**Land at Bilsham Road, Yapton**  
**Planning Reference: Y/70/22/DOC**

**Approval of details reserved by condition imposed under ref Y/91/17/OUT relating to Condition Nos 9 - surface water drainage and 27 relating to levels.**

**At this stage we would recommend that this condition is not discharged at this time until further information is provided and the comments below are addressed**

Drawing No. D1956-15-3

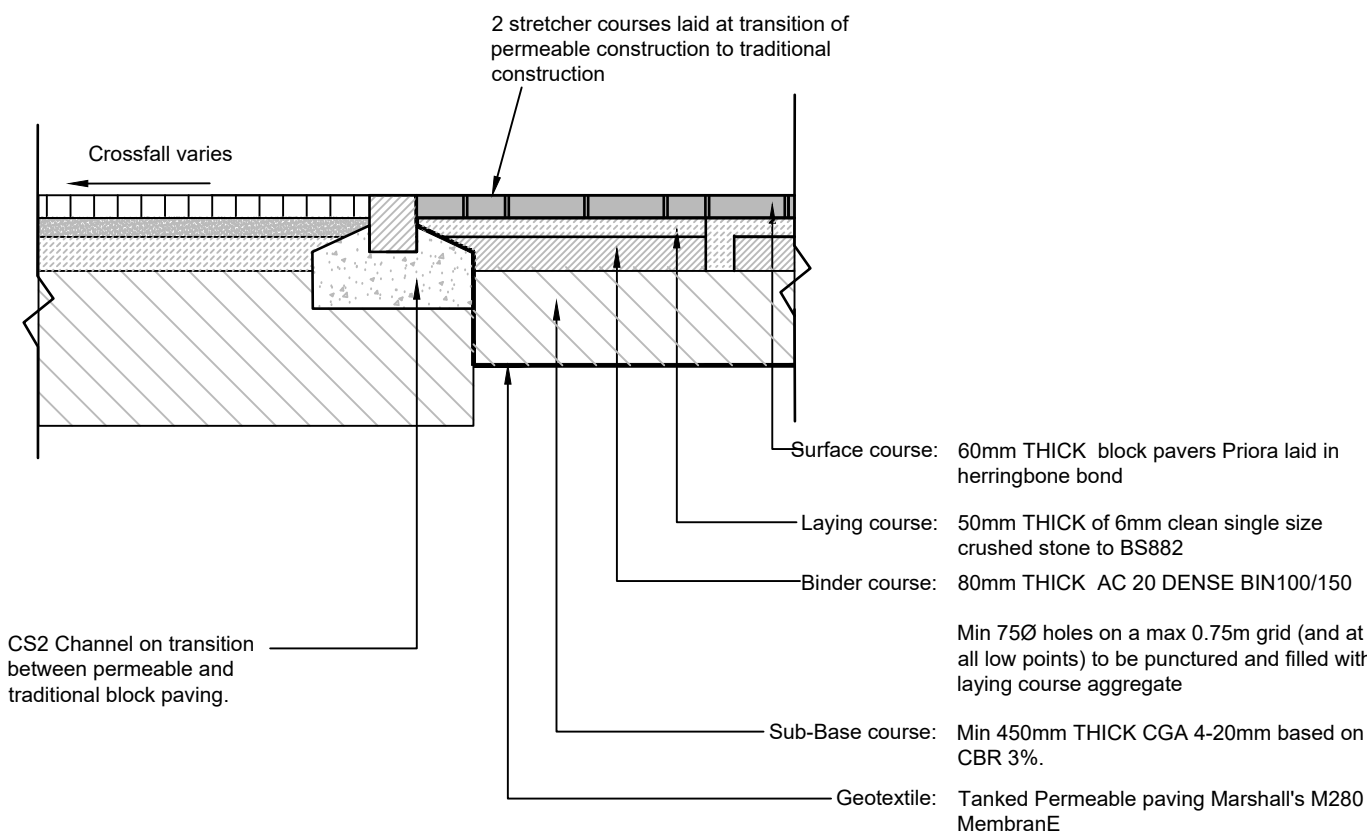
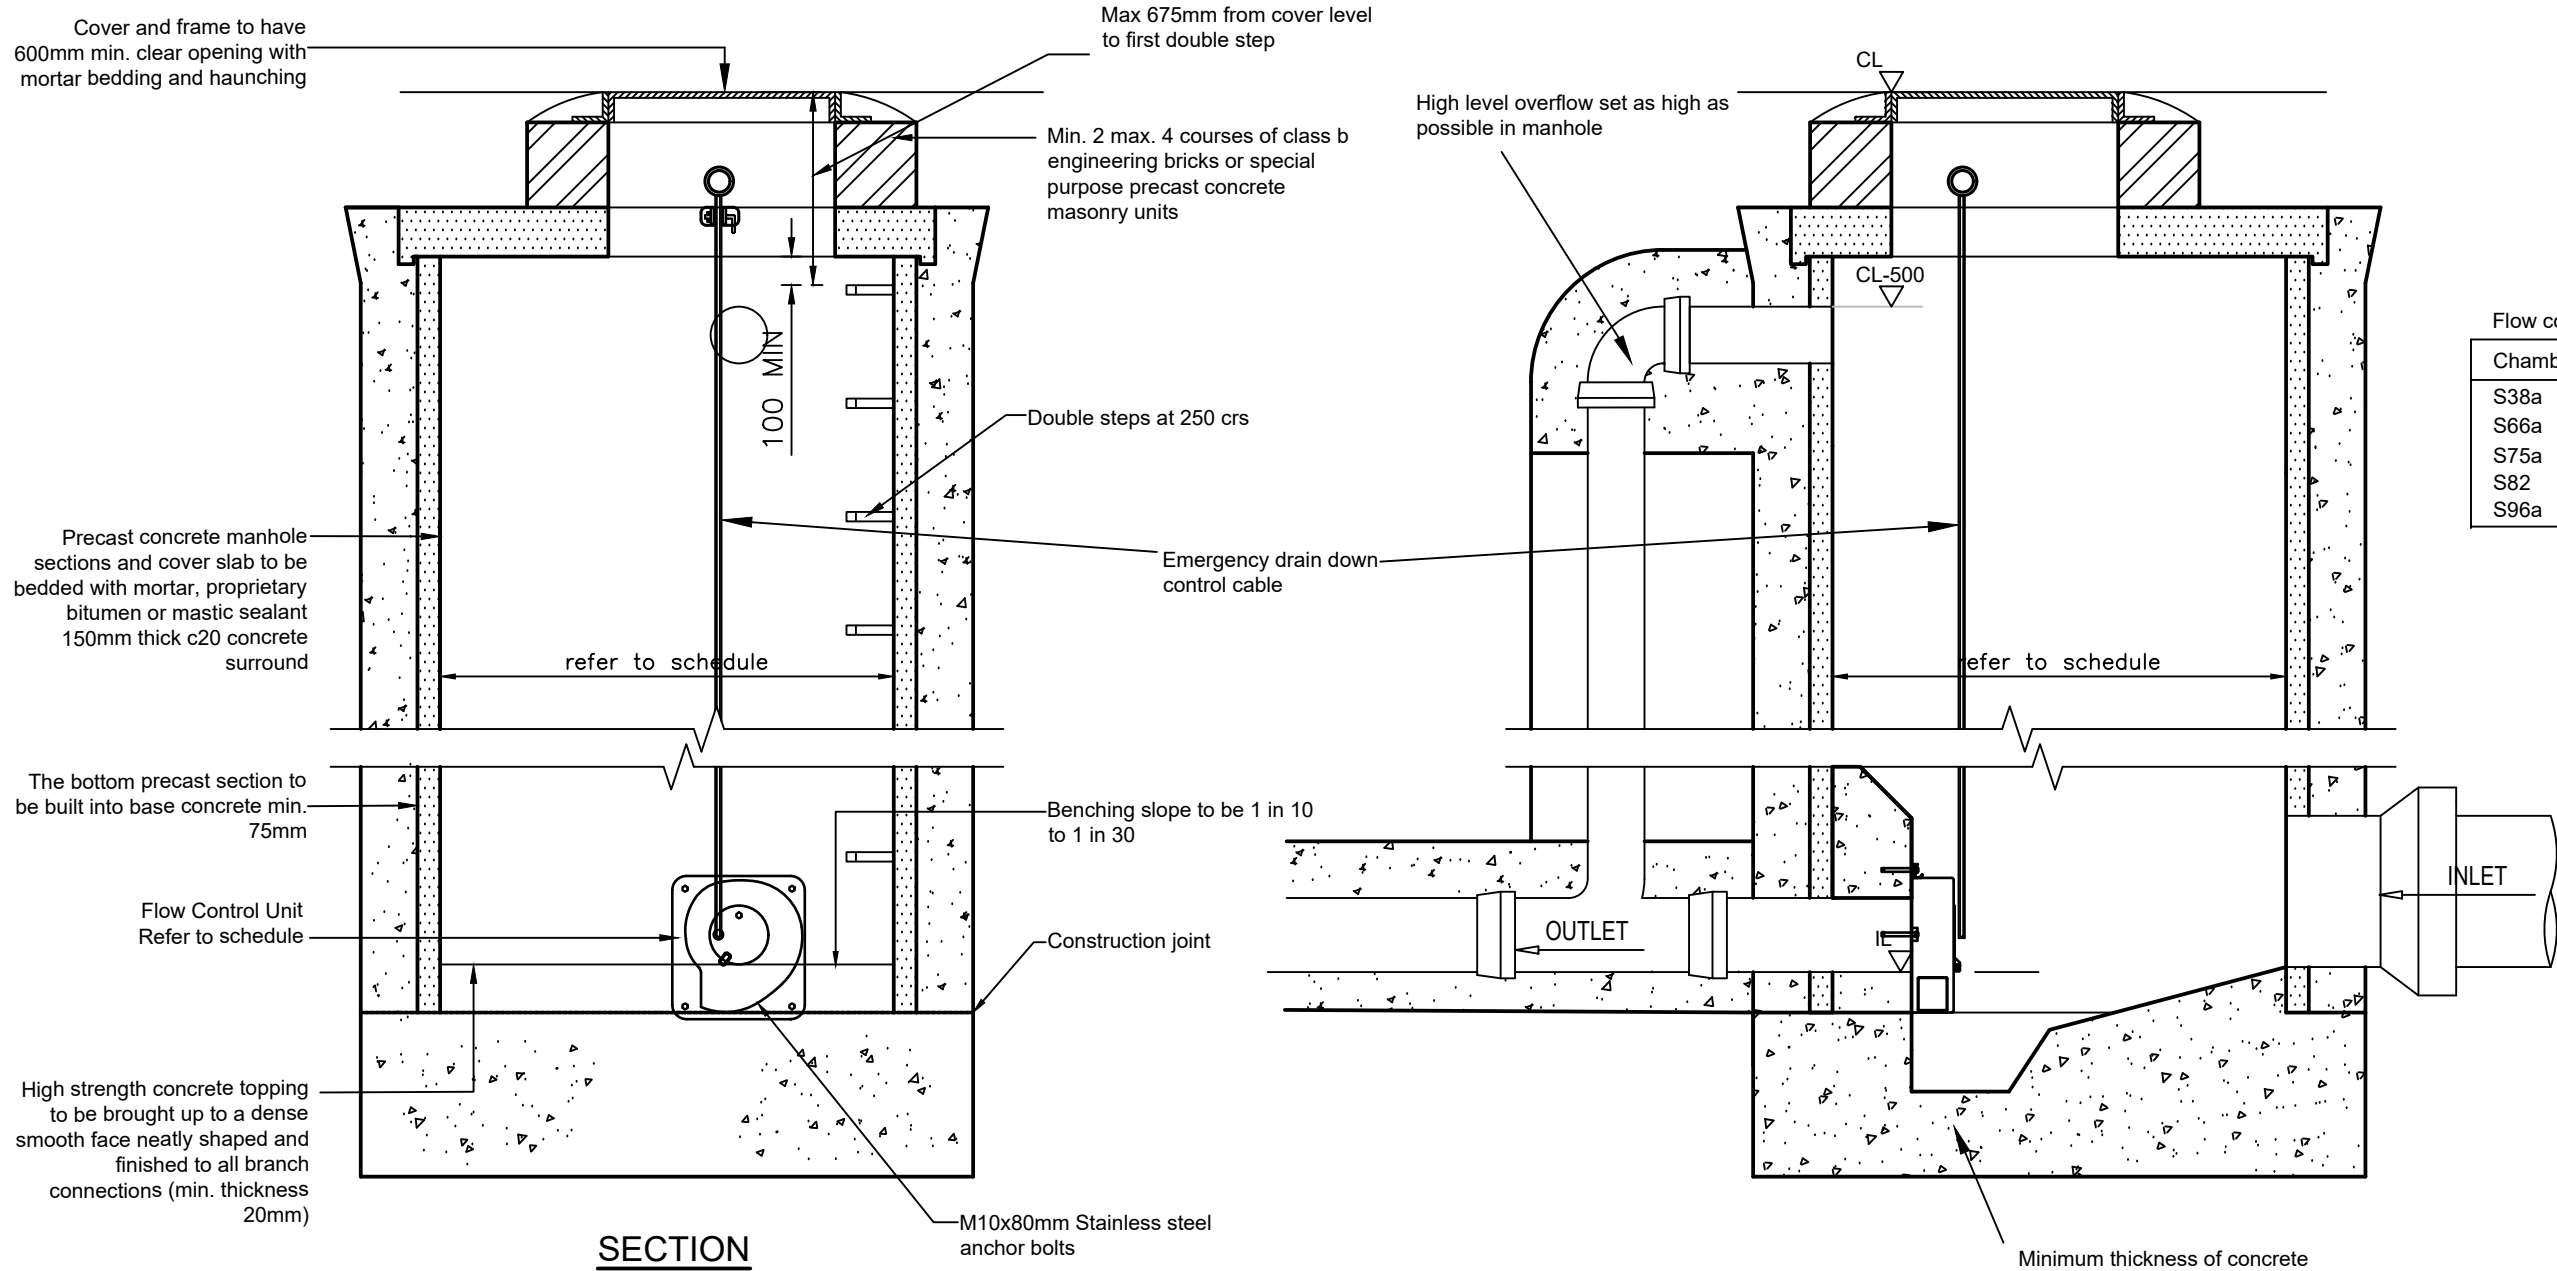
16. *Please provide a construction detail of permeable paving which clearly defines the construction, i.e. blocks, bedding, membranes, sub-base, tanking membrane. Materials and depths should be clearly defined. The construction detail shown on drawing D1956-15.2 conflicts with that shown on D1956-15-3A. These need to be updated to ensure there is no conflicting information. In addition to this its not clear why part infiltration has not been sought in areas where the infiltration has demonstrated that this is achievable. The applicant should clarify clear reasons as to why infiltration techniques have not been used for the permeable paving in the areas within the vicinity of the following test locations: TP05; TP04; TP01. 08/2/2023- This has now been received and we have no further comments.*
